**CITY OF PORTLAND, MAINE
DEVELOPMENT REVIEW APPLICATION
PLANNING DEPARTMENT PROCESSING FORM**

2/9/99
Application Date
Learning Center
Project Name/Description

TO: Chair Carroll and Members of the Portland Planning Board
FROM: Kandice Talbot, Planner
DATE: August 24, 1999
SUBJECT: The 32 Degree Masonic Learning Center For Children, 1903 Congress Street

RE: Site Plan Review
32° Masonic Learning Center
1903 Congress Street

PHOTOMETRIC PLAN

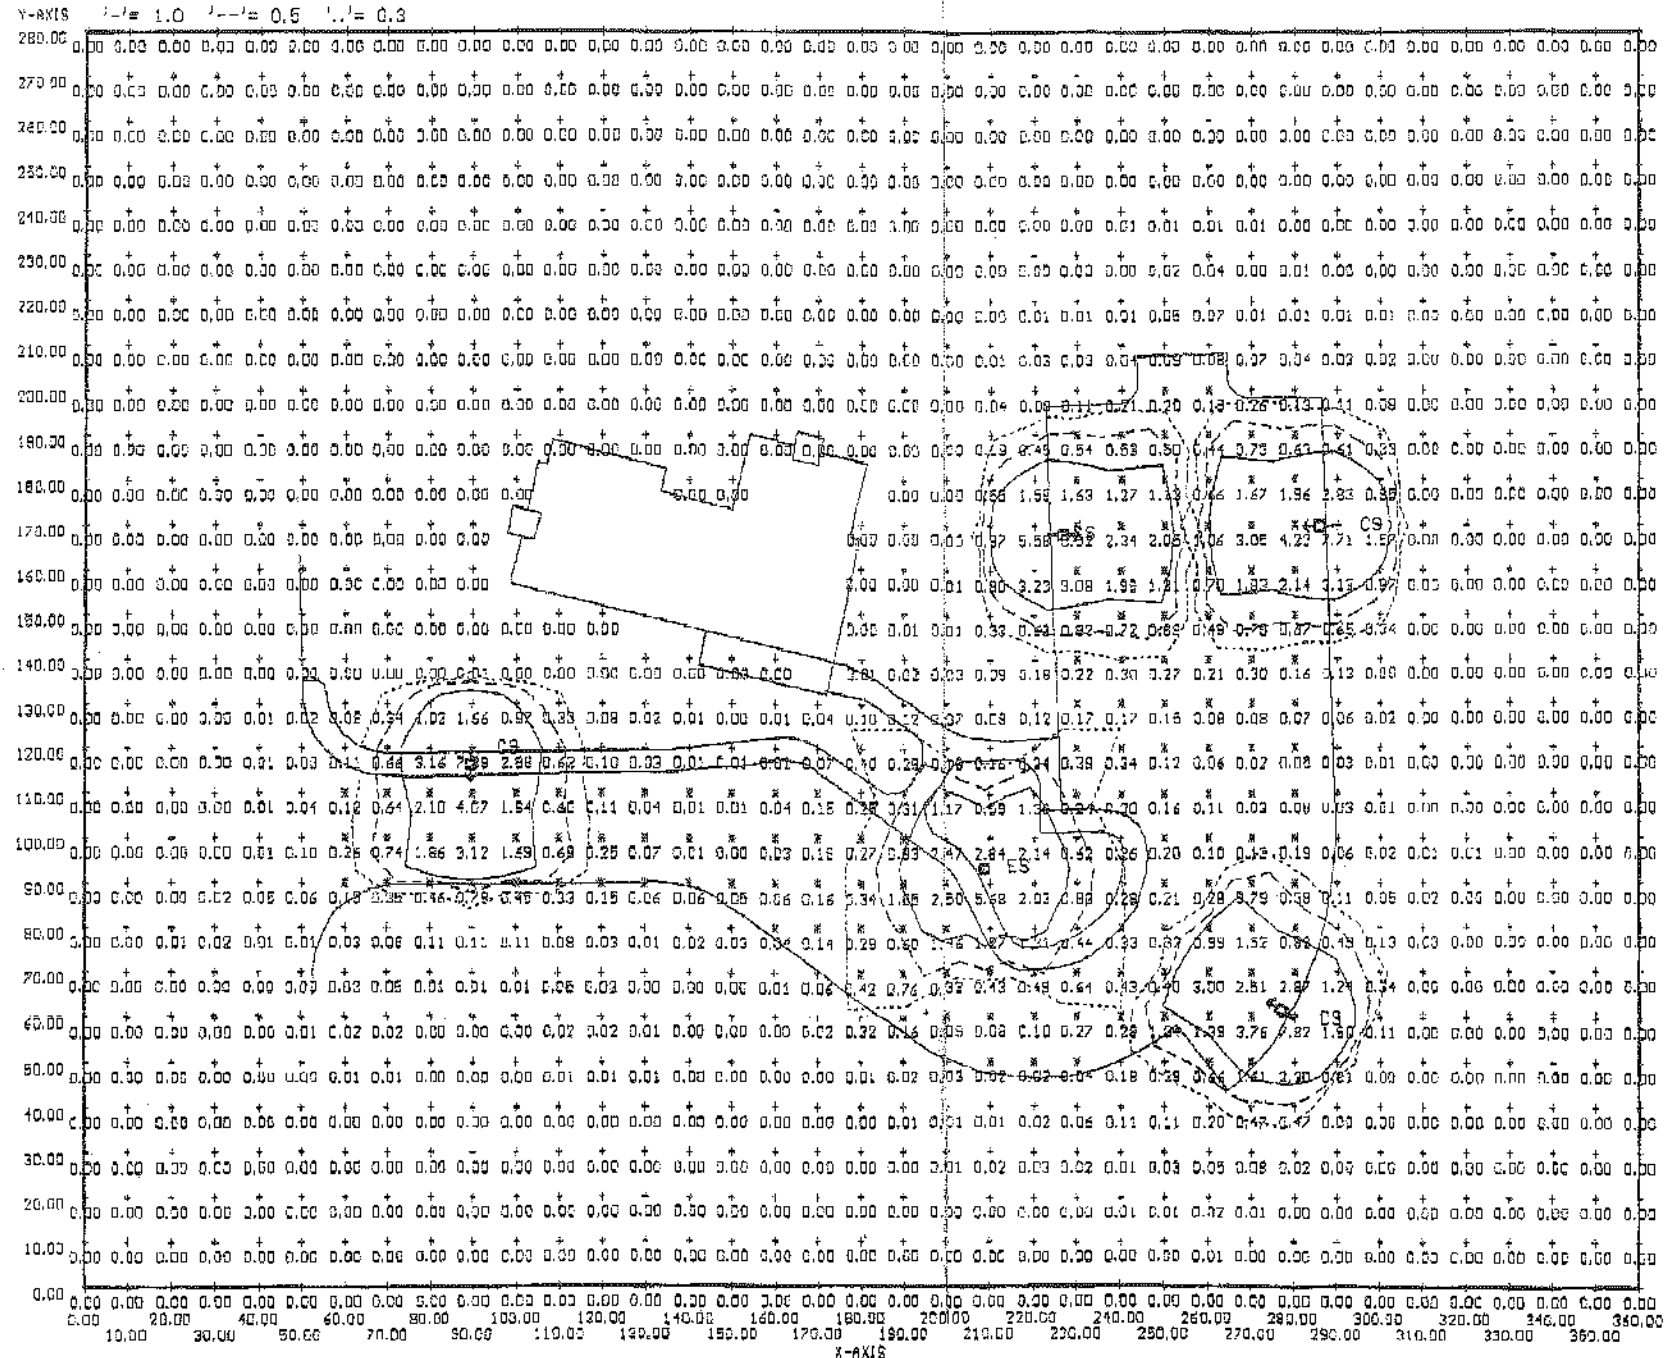
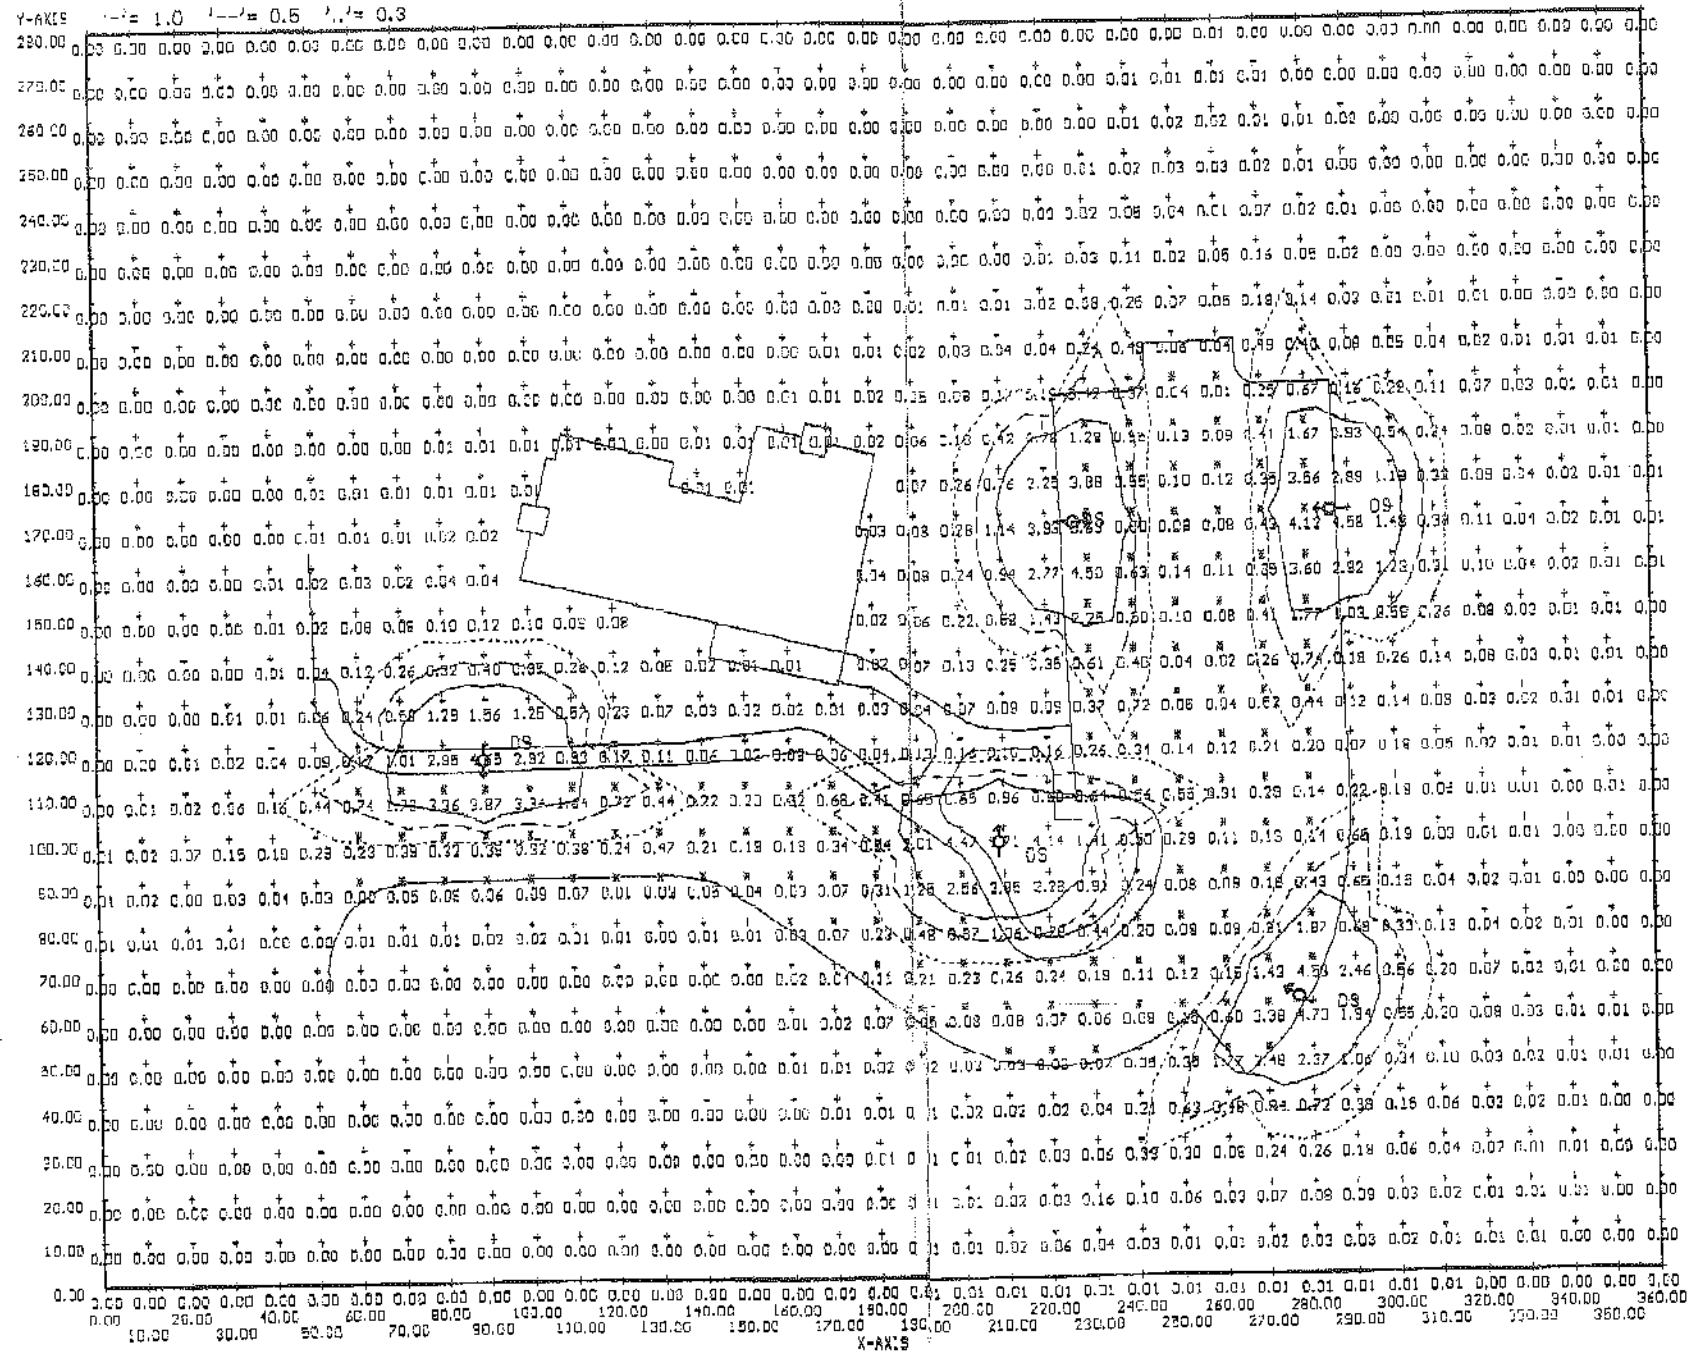
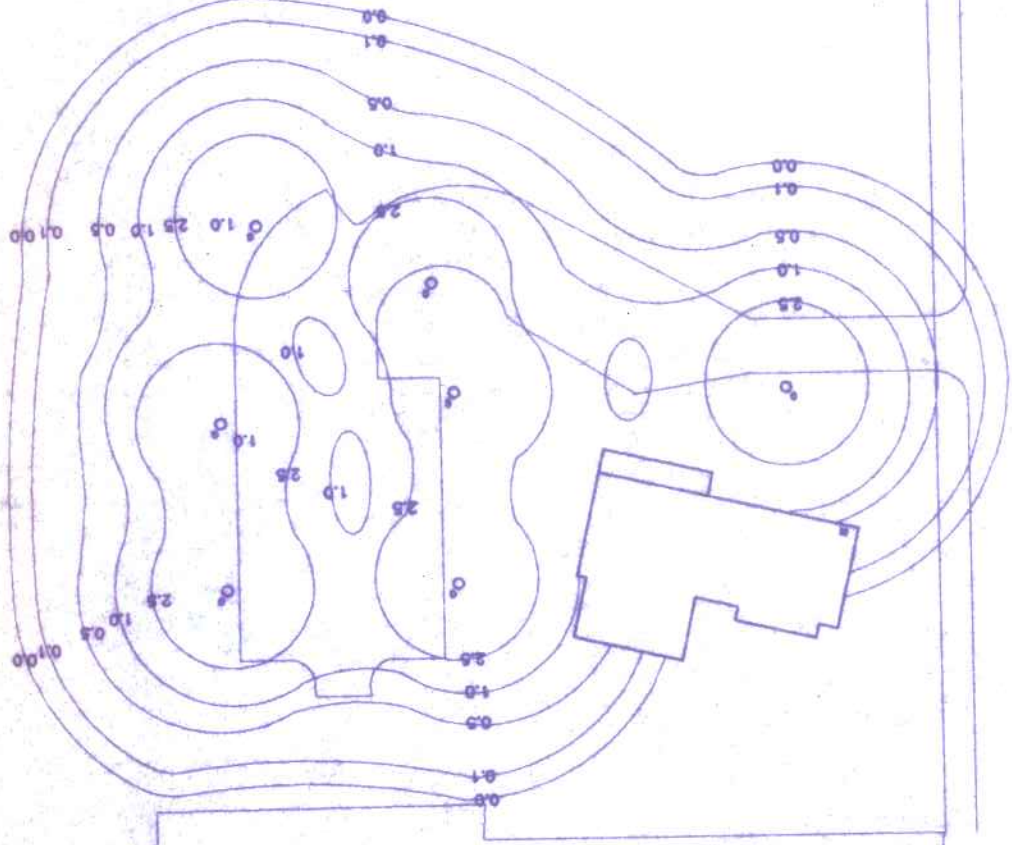
The Planning Board had a concern regarding the amount of lighting on the site. Proposed are five lights poles, 14 ft. high with 100 watt metal halide lights. The applicant has submitted a lighting plan, which is included as Attachment 5. After review of the plan, staff has asked that the applicant submit a revised plan showing the entire site and no spillover onto abutting property. It should be noted that based on the size of the site, it does not appear that there will be spillover onto abutting properties. Staff has indicated to the applicant that a different distribution pattern of the lighting may evenly distribute the lighting around the parking area with lower levels under the poles.

PAVING DETAILS

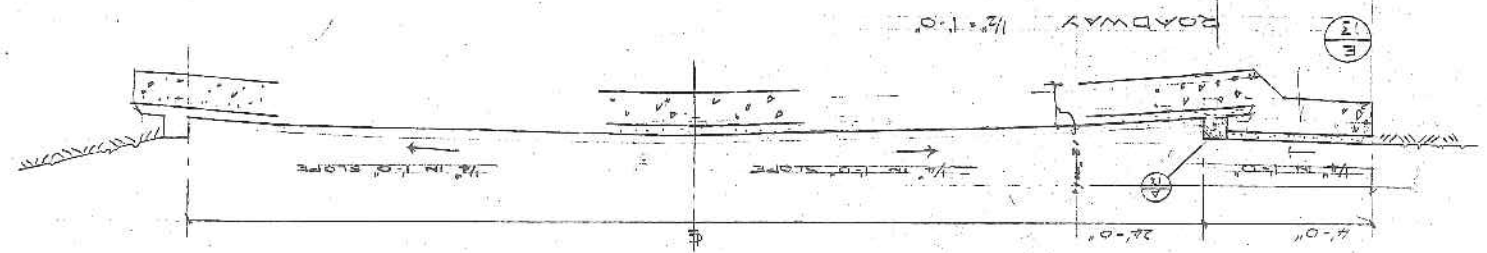
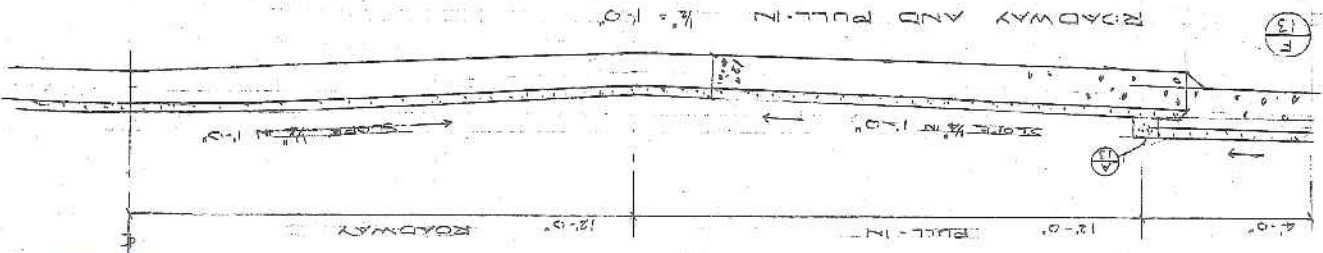
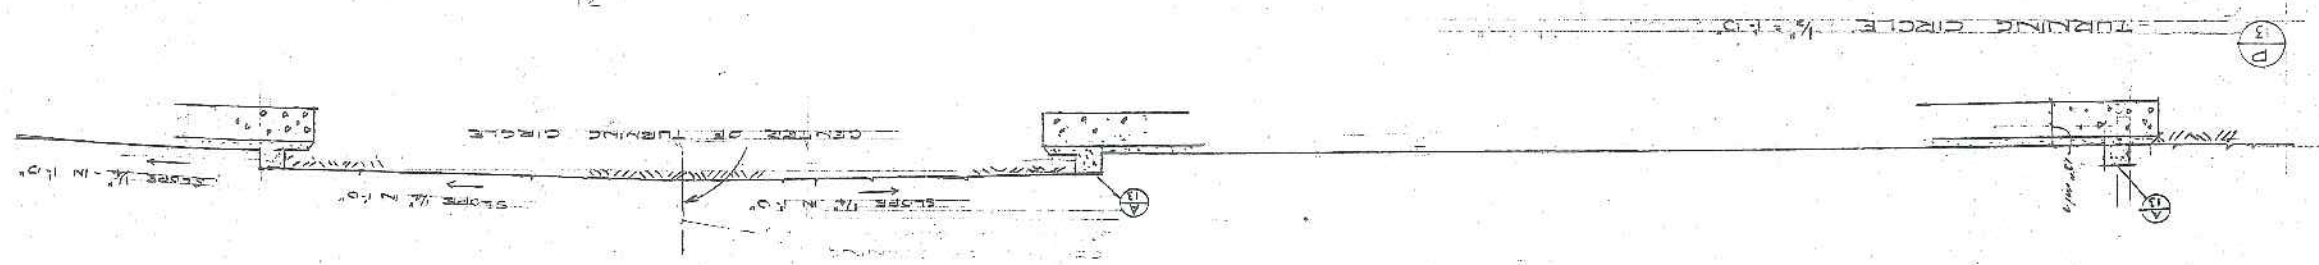
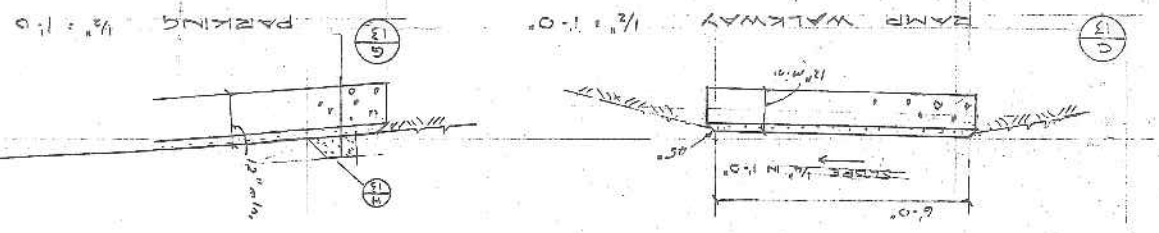
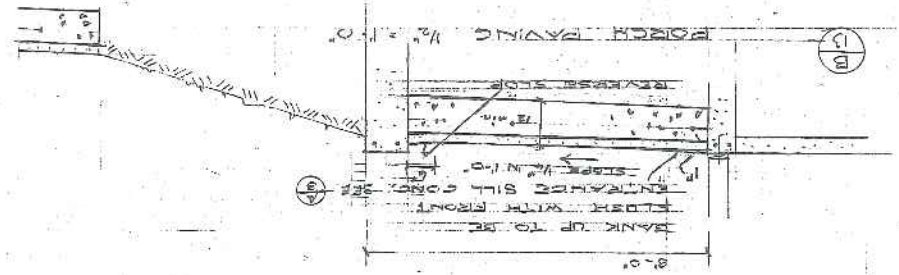
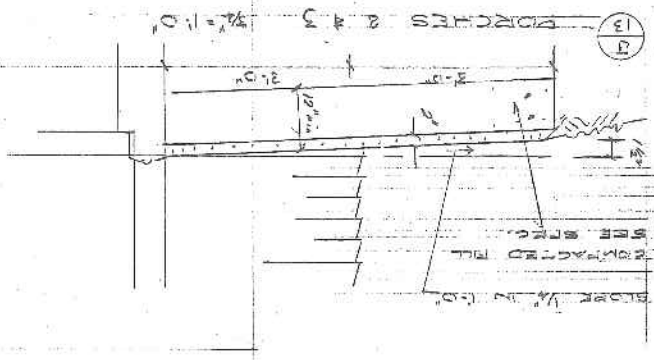
The applicant recently submitted revised engineered plans. The DRC has reviewed the revised plans and is recommending that the applicant provide details for sidewalks, both on-site and within the right-of-way, and for the stairs in the sidewalk. The detail for the installation for the storm drain infrastructure at the drive entrance must conform to City standards. These recommendations are all detail related and the DRC is satisfied with the stormwater plan at this time.

1. The plan should be clear that the installation of the storm drain infrastructure at the drive entrance must conform to Portland's Standards. The details should reflect the City's Standards so it is clear to a Contractor.
2. A detail for the sidewalk is needed; both for the site and the City's Standards.
3. A detail for the stairs in the sidewalk is also needed.
